An
Coimisiún
Pleanála

Inspector's Report ABP-323870-25

Whether the erection of a 282.96m² agricultural shed is or is not development or is or is not exempted development.

Gaurus, Ennis, Co. Clare.

SITE LAYOUT 1:500

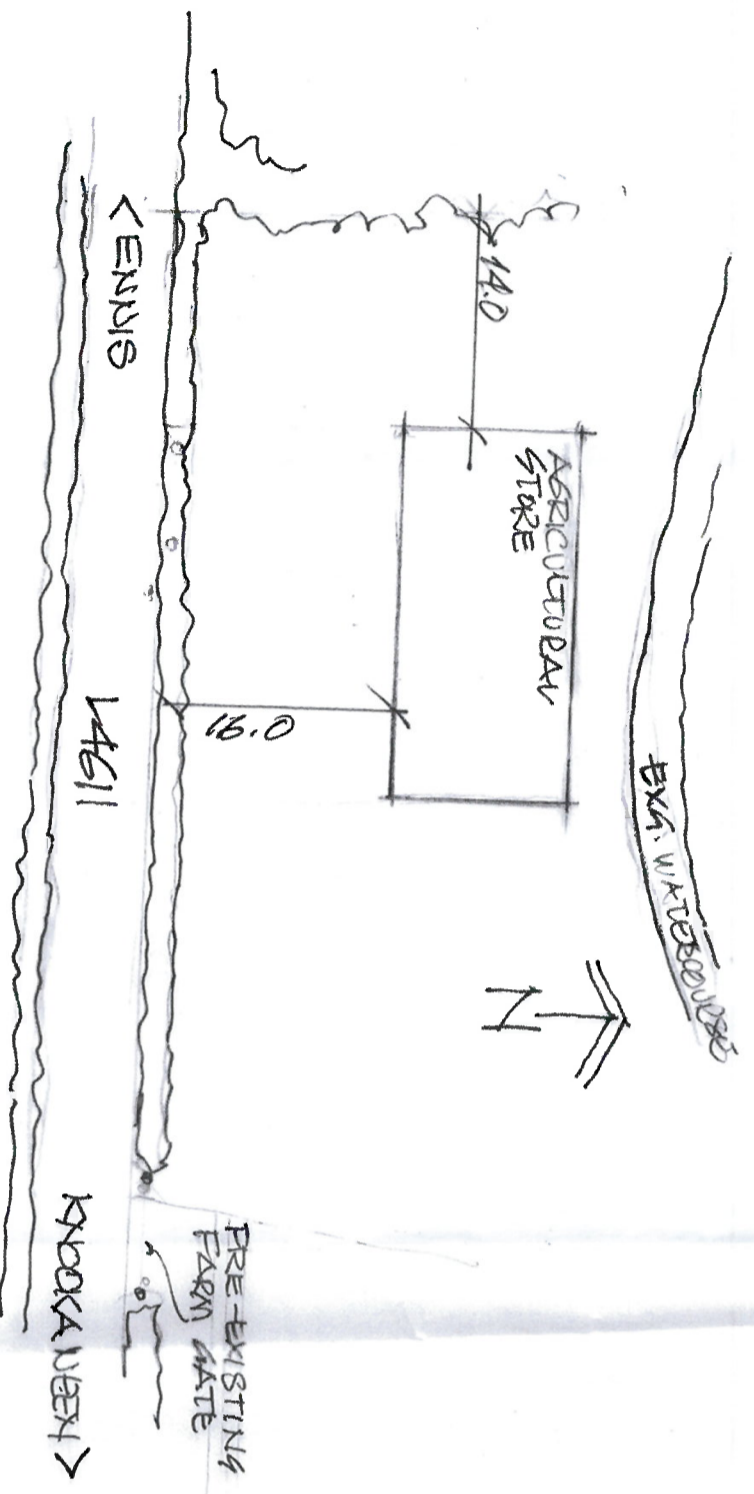
- 9.2.11. Condition and Limitation no. 5 associated with Class 9 requires No such structure shall be situated within 100 metres of any house other than the house of the person providing the structure or other residential building or school, hospital, church or building used for public assembly, save with the consent in writing of the owner and, as may be appropriate, the occupier or person in charge thereof.

- 9.2.13. In the first instance I note that the addresses provided on the letters of consent do not correctly correspond to the locations indicated on the extract from google maps provided by the Referrer.

- 9.2.14. Secondly, from a review of google street view I found that there are 3 no. additional dwellings situated along the L4611 which are situated less than 100m to both the west and south-west of the structure which are occupied and appear to be present prior to the structure subject to this referral as per street view on Google Maps. The street

view tool on google map presents images from 2024 where it appears that only ground works have occurred on site with some mounding present. The Eircode's of these are as follows V95 E4W5, V95 V2TR, and V95 D8K0. No letters of consent from the occupants of these dwellings have been provided.

- 9.2.15. Therefore, in conclusion the structure fails to comply with Condition Limitation 1 and 5 of Class 9 of Schedule 2 Part 3 of the Planning and Development Regulations 2001 (as amended).
